WELWYN HATFIELD COUNCIL
PLANNING CONTROL COMMITTEE – 10 APRIL 2008
REPORT OF THE CHIEF PLANNING AND ENVIRONMENTAL HEALTH OFFICER

S6/2008/118/LB

INTERNAL ALTERATIONS

GREAT NAST HYDE HOUSE, WILKINS GREEN LANE, AL10 9RB

JOB TITLE		
GREAT NAST HYDE HOUSE HATFIELD		
DRAWING No	REVISION	
P9096-PN02	C	
DRAWING TITLE		
PLANNING NOTES FIRST FLOOR		
DATE	JOB No	SCALE
11.10.07	9096	1:75

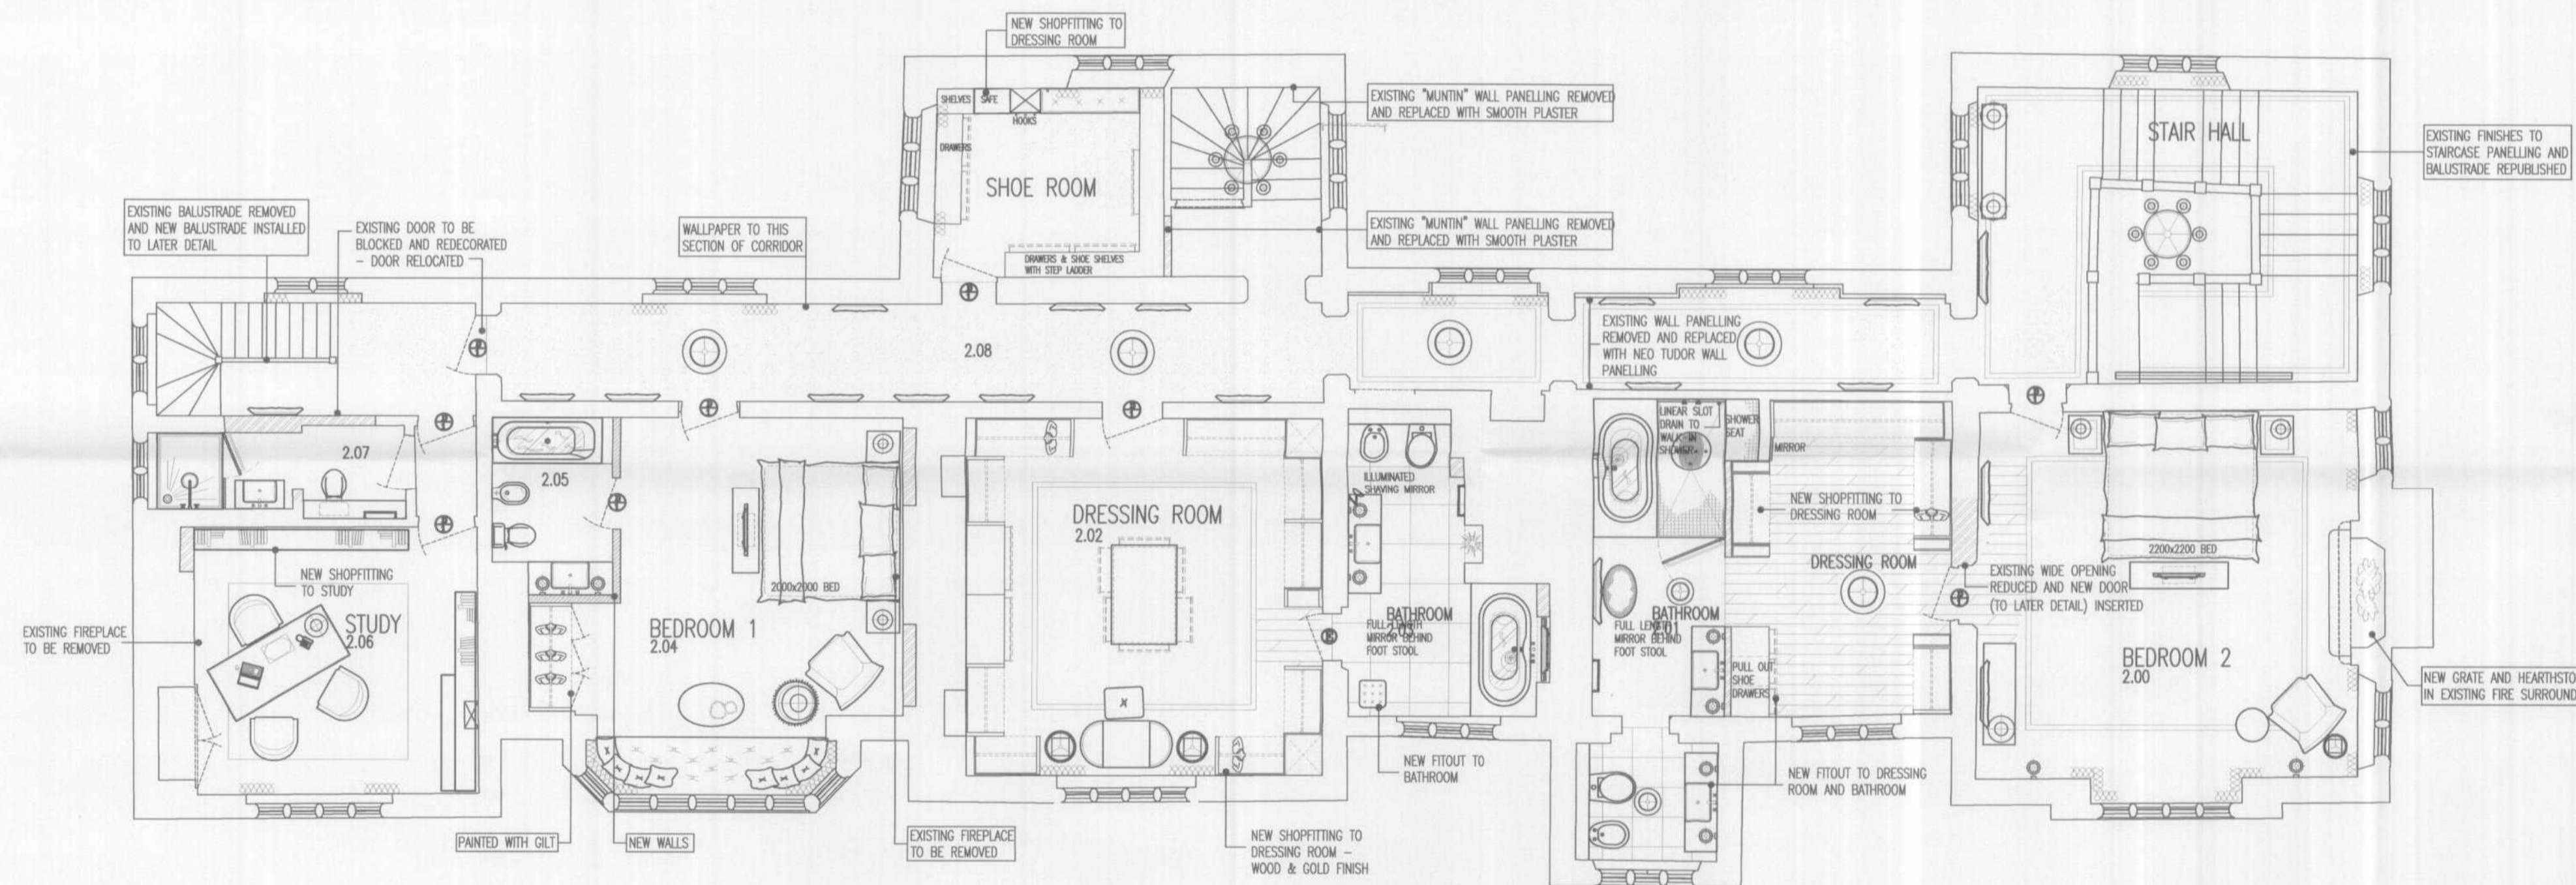
- The fireplaces on the first floor within the study and bedroom 1 are to be retained.
- The panelling in the back stairs retained. This area is labelled “muntin” wall panelling on the original plans submitted.
- The two Georgian doors on the ground floor are to be retained.
- The “Adam” fireplace would be removed but stored on site.

- The fireplaces on the first floor within the study and bedroom 1 being retained as existing.
 - The panelling in the back stairs retained as existing. This area is labelled “muntin” wall panelling on the original plans submitted.
